## **FIRE RISK MANAGEMENT, INC**

# **Memo Report**

**Subject: Review of Need for Smoke Dampers in Basement Level Corridors**

As requested, Fire Risk Management, Inc. (FRM) has performed a review of the information that was provided with regards to the potential need to install smoke dampers in one or more of the ventilation ducts installed at the Basement Level of the Westin Hotel at 157 High St. in Portland, ME.

Sheet Title:
B-1 & B-2 BASEMENT LEVEL LIFE SAFETY PLANS

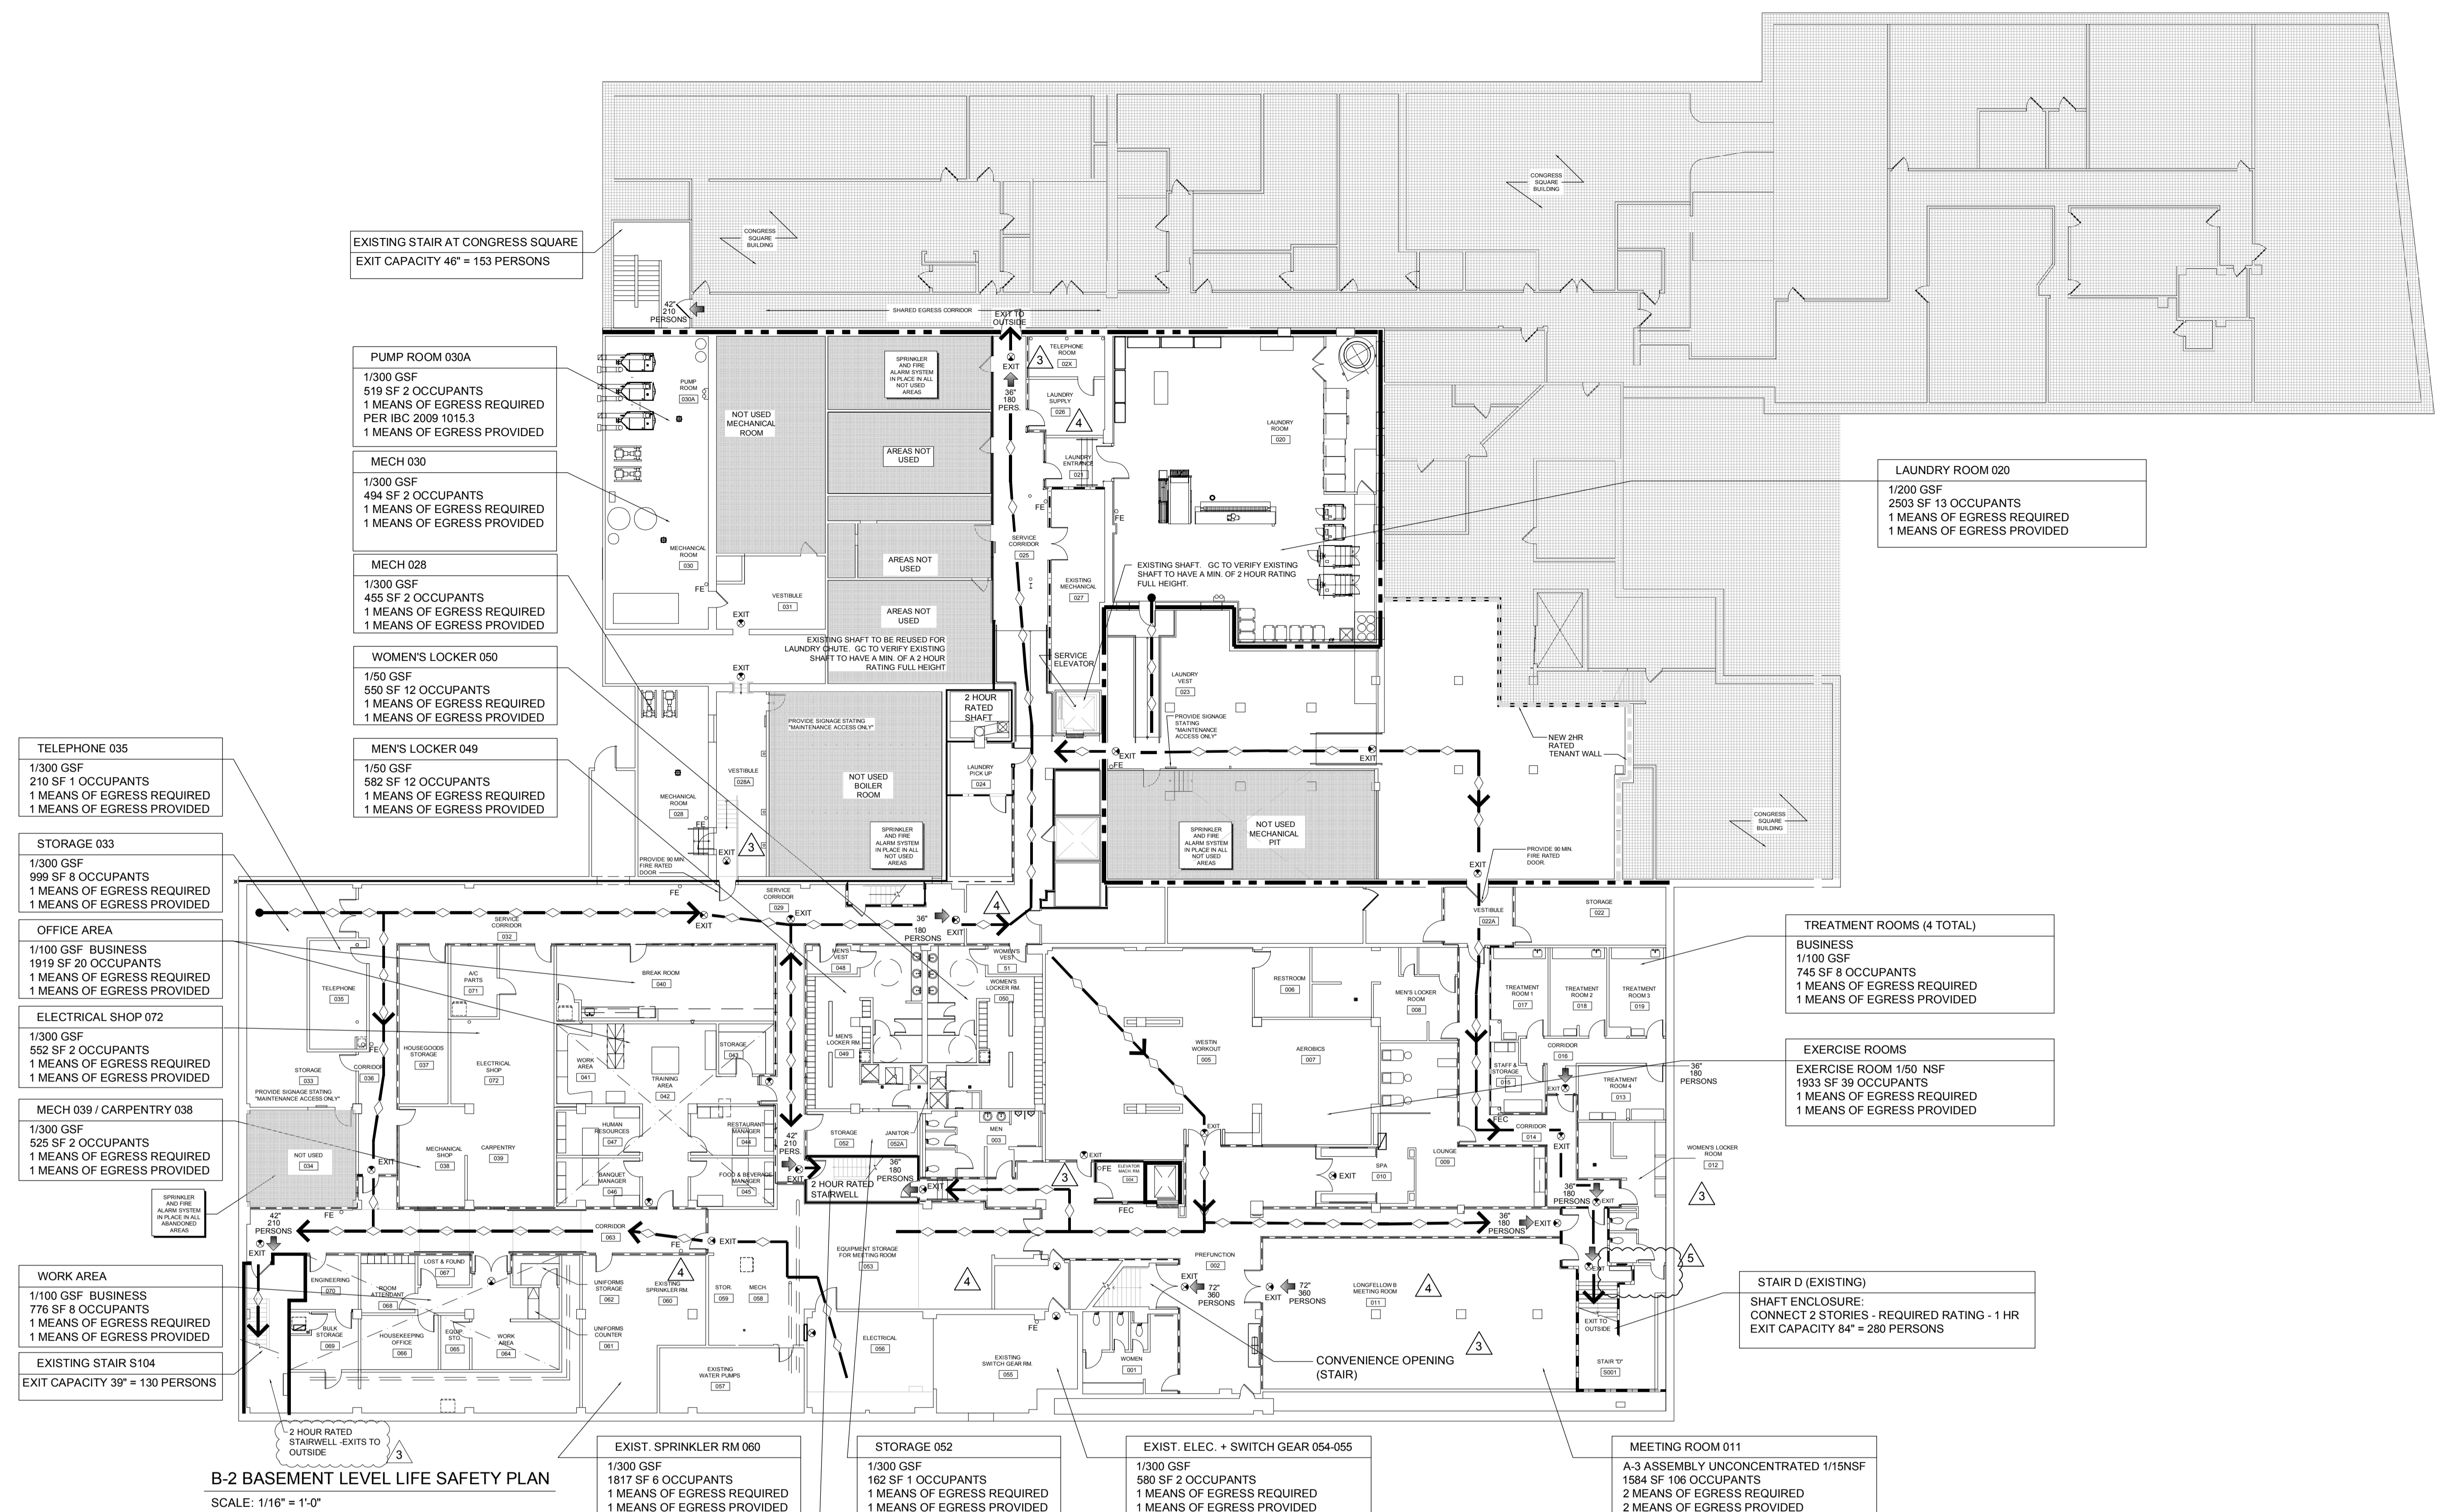
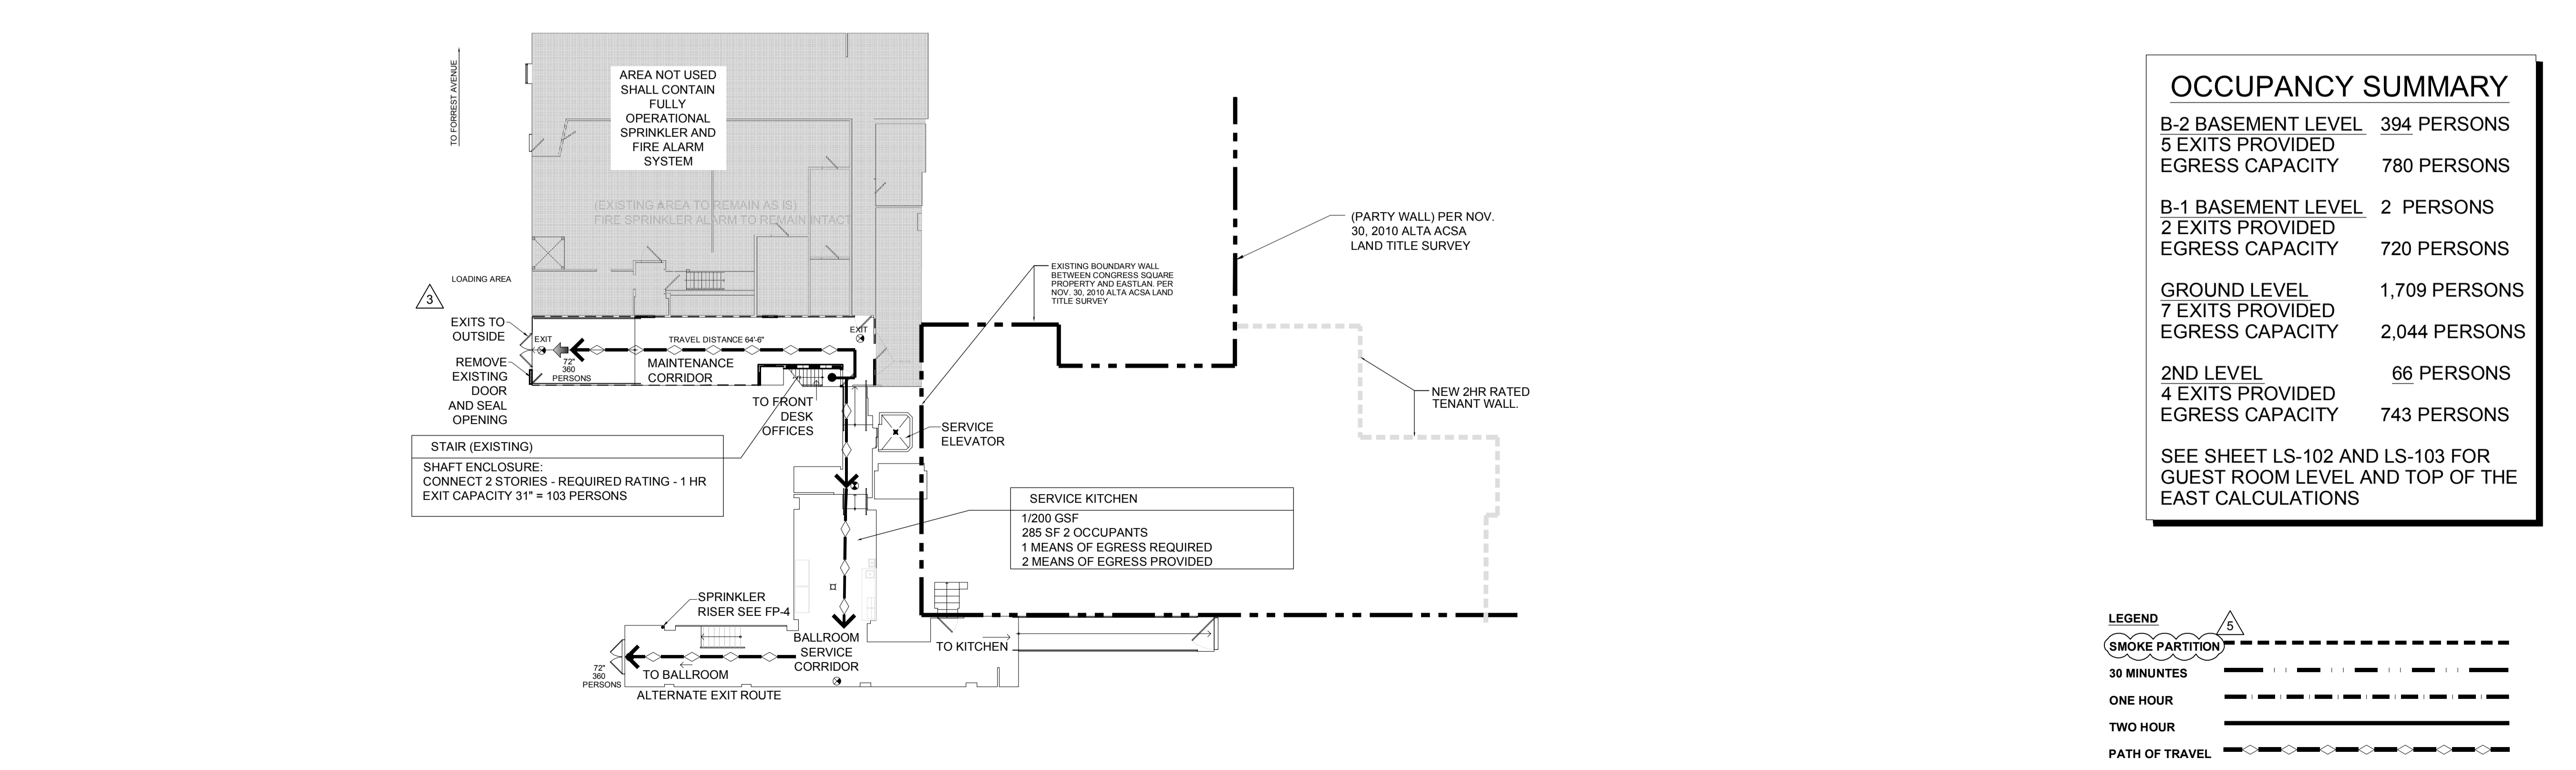
The Corridors in question are those that are located within the Basement Level of the building and are used to provide access to the exits; as such are termed “egress access corridors.” It has been indicated by IDC that the City’s Code Enforcement Officer has raised questions about the installation of return (or exhaust) air ducts that facilitate the movement of return air from a number of rooms into the corridor(s); whereby the air is then picked up by the exhaust air ducts that remove air from the corridor (return air grills installed in corridor ceiling). The apparent concern by the City is the fact that smoke from a fire located within one of these spaces would be able to move directly to the corridor via the exhaust/return air duct. As such, it was apparently stated that the codes (IBC and/or the Life Safety Code) would require that a smoke damper be installed in these ducts.

Having reviewed the specifics of the planned ventilation system design, it is agreed that there is a problem with code compliance, albeit not one involving a requirement for smoke dampers. It is understood that IDC has been treating all exit access corridors throughout the building as being constructed using “smoke resistant” barriers; effectively calling them “smoke partitions.” However, this proposed approach is actually “above & beyond” the actual code requirements for this application/occupancy. The general requirements within the Life Safety Code that address “Exit Access Corridors” [NFPA 101 – 7.1.3.1] do include a requirement that for areas serving more than 30 occupants, they must be separated from the rest of the building by 1-hour fire rated barriers; unless otherwise allowed by the other chapters of that code. The various areas located within the Basement level of this building are classified as “Business” occupancies. As outlined in Chapter 38, Business Occupancies, of this code; when the building is fully protected by an automatic sprinkler system, there is no specific rating applied to the corridor walls (or ceiling); either for fire or smoke resistance [ref. paragraph 38.3.6.1(3)].

The above requirements are very similar to those listed in the IBC; section 1018.1 [ref. Table 1018.1]. However, it is also this section of the IBC that then poses a problem for the current ventilation system design for this area. The IBC prohibits the use of corridors as “return air plenums”, which is how they are being used in the current IDC design; for those instances where a corridor is directly connected to an adjacent space via a exhaust/return air duct. However, in this instance the codes do allow the space that is above the ceilings of corridors to act in the capacity of a return air plenum [ref. 1018.5.1]. If the ventilation system

It is understood that there have been a number of issues that have arisen in the past regarding the requirements for the various corridors throughout the building; regarding just what sort of fire and/or smoke ratings are required for each. In this instance, it was a decision within the IDC Team, not a code requirement, to protect all corridors that provide access to exits with barriers/partitions that, as a minimum, can resist the passage of smoke. Many of the corridors that are currently designated as being “smoke partitions” within the building design plan would not be required by the codes. This includes the corridors of interest at the Basement level. As such, there would be no requirements for any penetrations in the corridor walls or ceilings to be provided with smoke dampers. However, it is also true that the current design of the ventilation system within these areas (corridors) is not code compliant.

As discussed in our recent onsite meeting, it is recommended that the ventilation system design be modified such that all transfer of return air occurs within the space above the ceilings of the corridors; e.g., ducts from the spaces where air is being exhausted should terminate in the space above the ceilings and not within the corridors. This modification to the ventilation system design will not only remove any questions regarding the potential need for smoke dampers, but will make this area fully code compliant.

design was modified to utilize the space above the ceiling to facilitate return air movement, this area then becomes code compliant.
